The Kemsley Mill K4 Combined Heat and Power Generating Station Development Consent Order

PINS Ref: EN010090

Applicant's Response to ExQ1

Document 9.3

Limits of deviation for work no.1 g) CHP Pipe Bridge, including pipes and cables

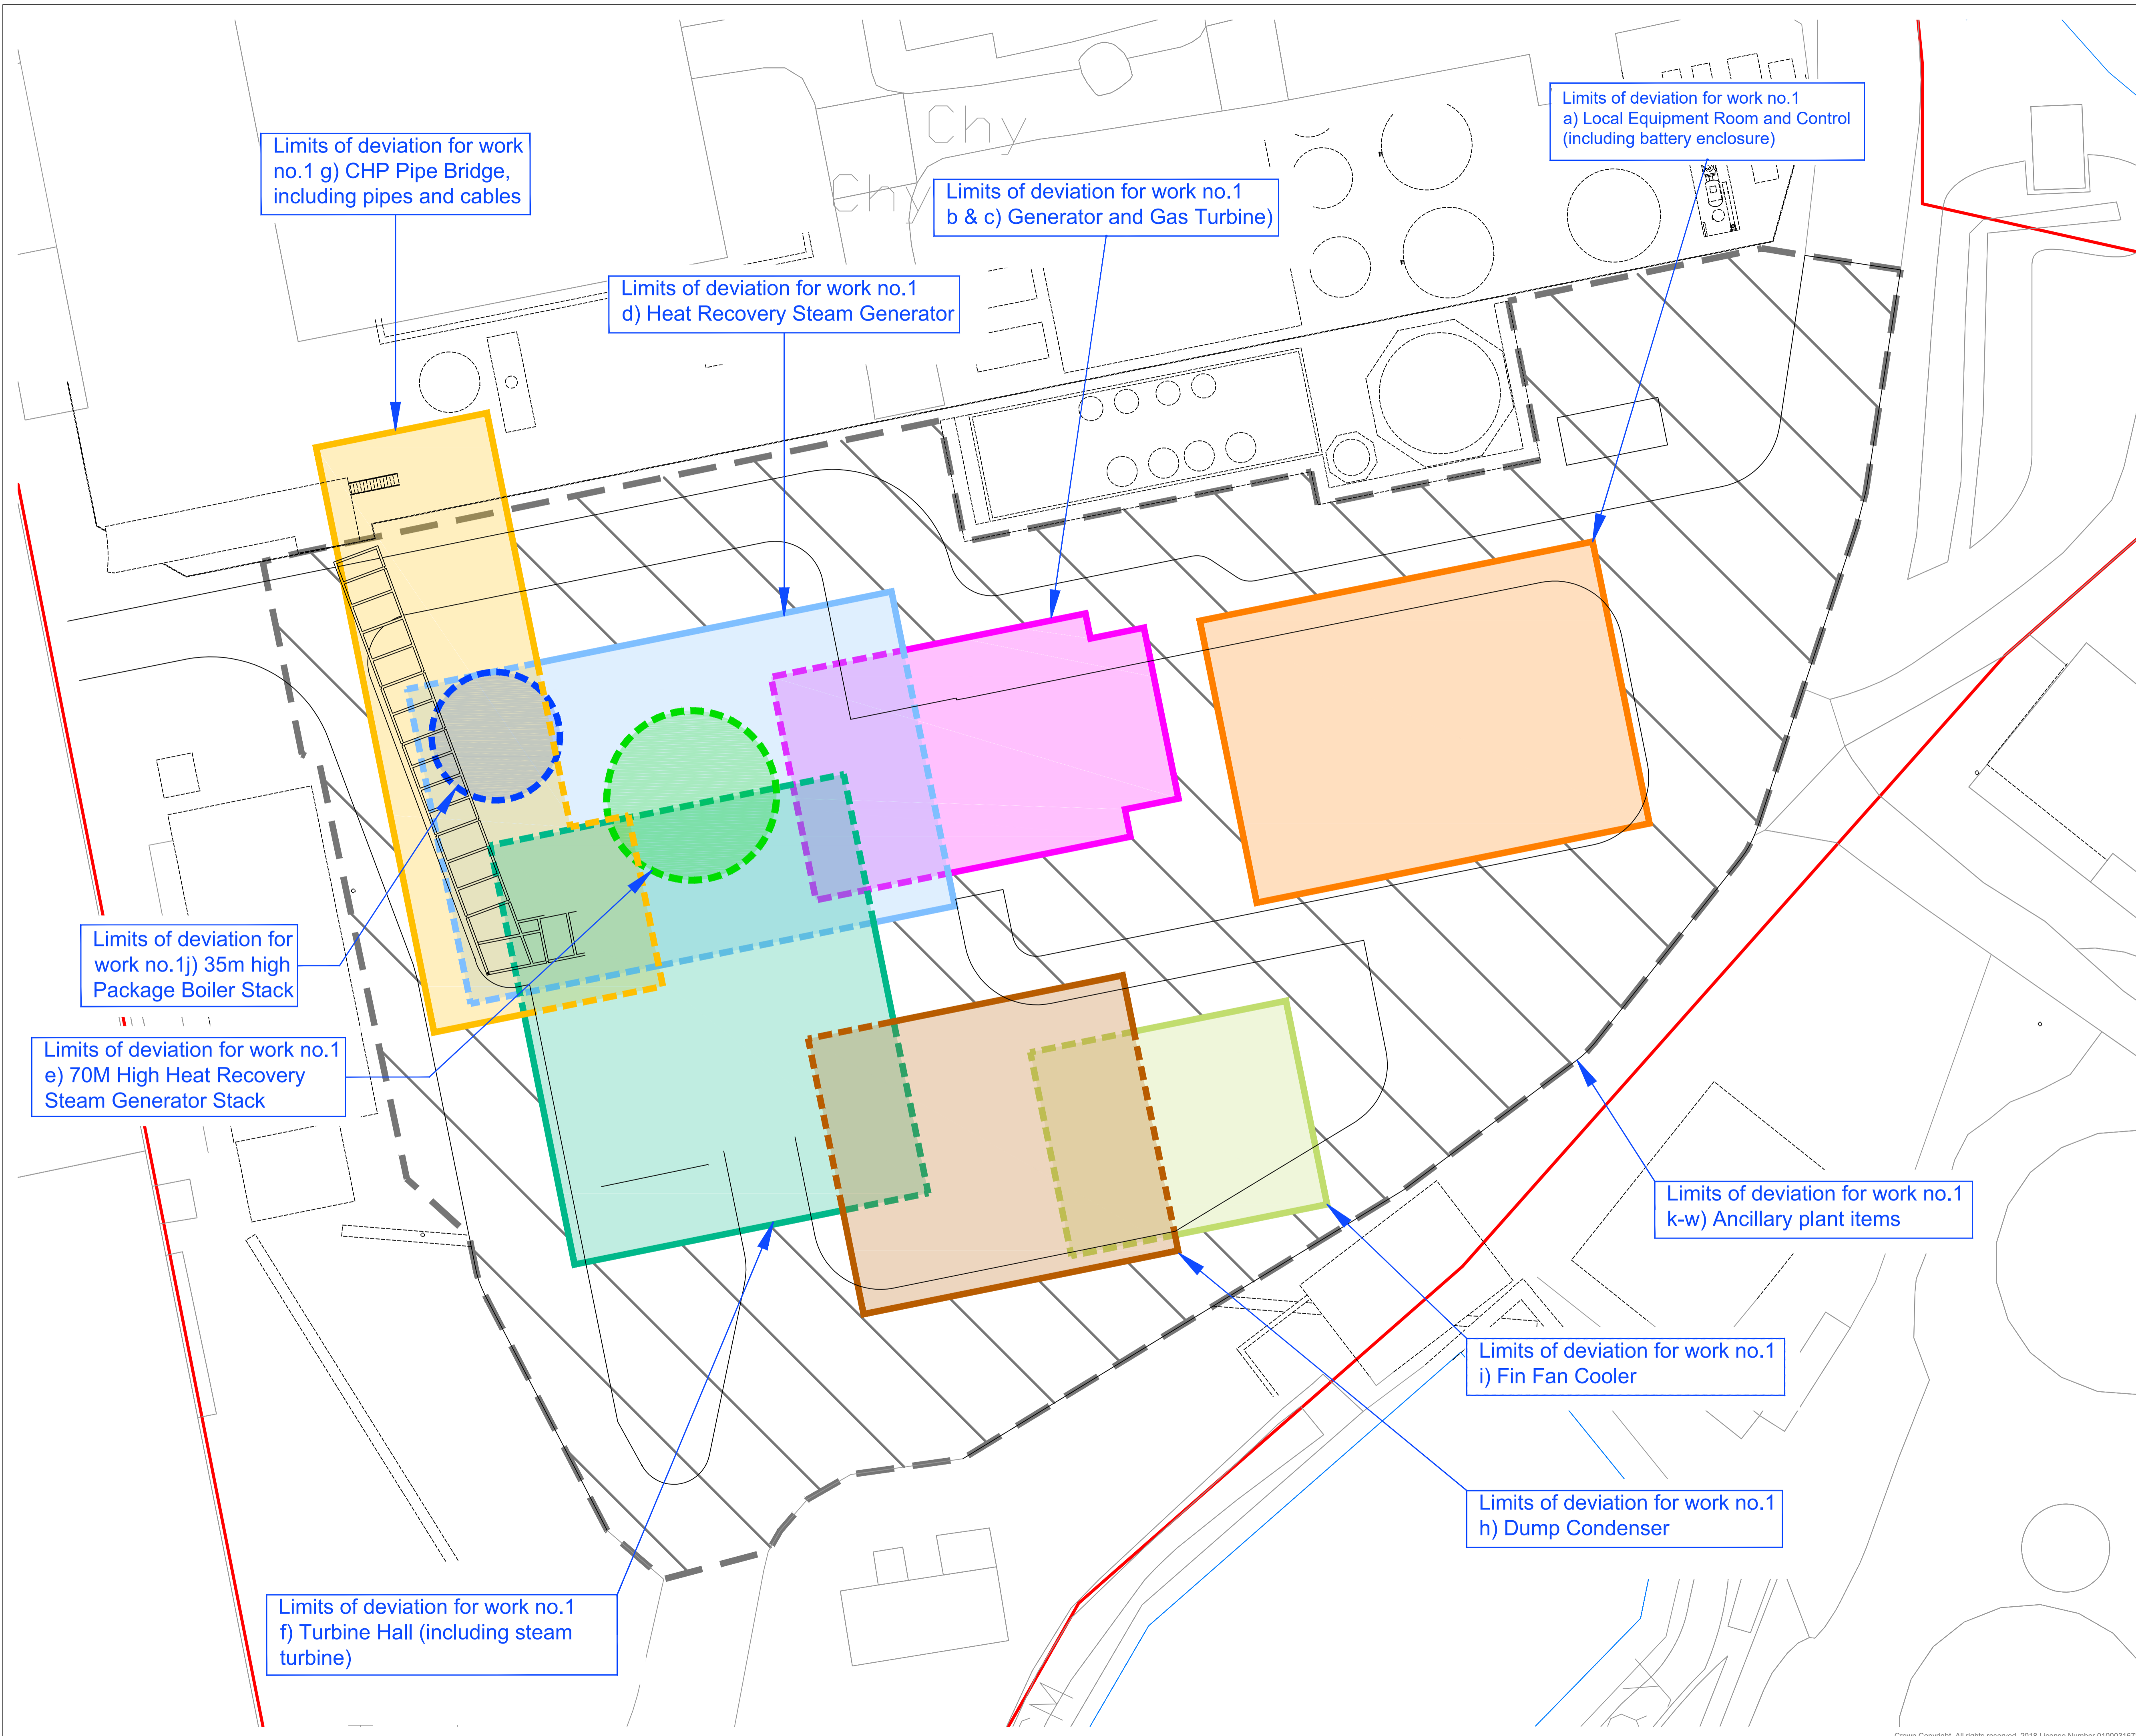
<p>Q1.1.3</p>	<p>Applicant</p>	<p>The Works Plans [AS-004 and AS-008] for the alternative boiler options show the limits of deviation.</p> <p>Please could the Applicant demonstrate that the ES considered the effect of each alternative within 5m variation in any direction as described in paragraph 10.4 of the Design and Access Statement (DAS) [APP-058]</p> <p>How was the 5m parameter determined?</p>	<p>The 5m parameter was defined on the basis of Table 2.1 of the ES (i.e. maximum dimension parameters) and the degree of flexibility needed and inherent in facilitating the final design and layout of the development as advised by the project engineers. As stated for Q1.1.2 the ES has been undertaken on the basis of the parameter plans presented as Figures 2.4a and Figure 2.4b of the ES (Document No. 4.5 and No. 4.9). All topic authors have reviewed the parameter plans and based their assessments upon these as relevant. The four topics whereby a variance in 5m in terms of location could have the potential to make a material difference to the assessments undertaken are air quality (with resultant effects on ecology and human health), noise, landscape and visual impacts and heritage for which a response in turn is provided below. A variance in location of 5m is not material to the likely significant effects of the development with regard to traffic and transport, climate change, ground conditions, water environment or ecology (except by virtue of in-direct effects from pollutant deposition).</p> <p>RPS - Air Quality - For air quality, the dimensions of the buildings used within the model were as set out in Table 2.1 of the ES. The consideration of alternative stack locations is set out in Q1.1.2. With regard to the potential 5m variance for all other buildings as set out in chapter 5, downwash effects caused by buildings near the stack can affect ground level concentrations. Low pressure on the leeward side of buildings can bring the plume to the ground closer than would be the case for no building. The impact of a change in building locations will be a change in the location of where the maximum impact occurs over the short-term, rather than a significant change in the magnitude of the maximum prediction. The results in Table 5.18 show that the maximum</p>

<p>Process Contribution for NO₂ and CO is well below 10% of the relevant AQAL. As such, the impacts have been screened out as having an insignificant effect, regardless of the location of the maximum short-term impact. On that basis, a 5 m change in the building locations would not affect the conclusions of the assessment.</p> <p>RPS - Landscape - Only the two tallest buildings (steam generator and turbine hall) and the two stacks would be visible from surrounding public areas. The size, mass and height of these elements (and all other infrastructure that are not visible) would not be altered by their movement by up to 5m within the limits of deviation. The visibility of the K4 development would not be increased and the character of the townscape and surrounding landscape would not be further altered through the movement of proposed buildings and infrastructure within the limits of deviation. The LVIA has therefore assessed the worst case scenario.</p> <p>Heritage - See Q1.1.2.</p> <p>Noise and Vibration - As noted at paragraph 7.6.41 of the ES "Whilst the results above relate to assessment based on Figures 2.4a&b in Chapter 2, minor changes to the site layout would be unlikely to result in any significant changes to the levels predicted or the impact or effect outcomes." It is not considered that the limited difference between plant locations by up to 5m would affect the results of the noise modelling exercise undertaken.</p>
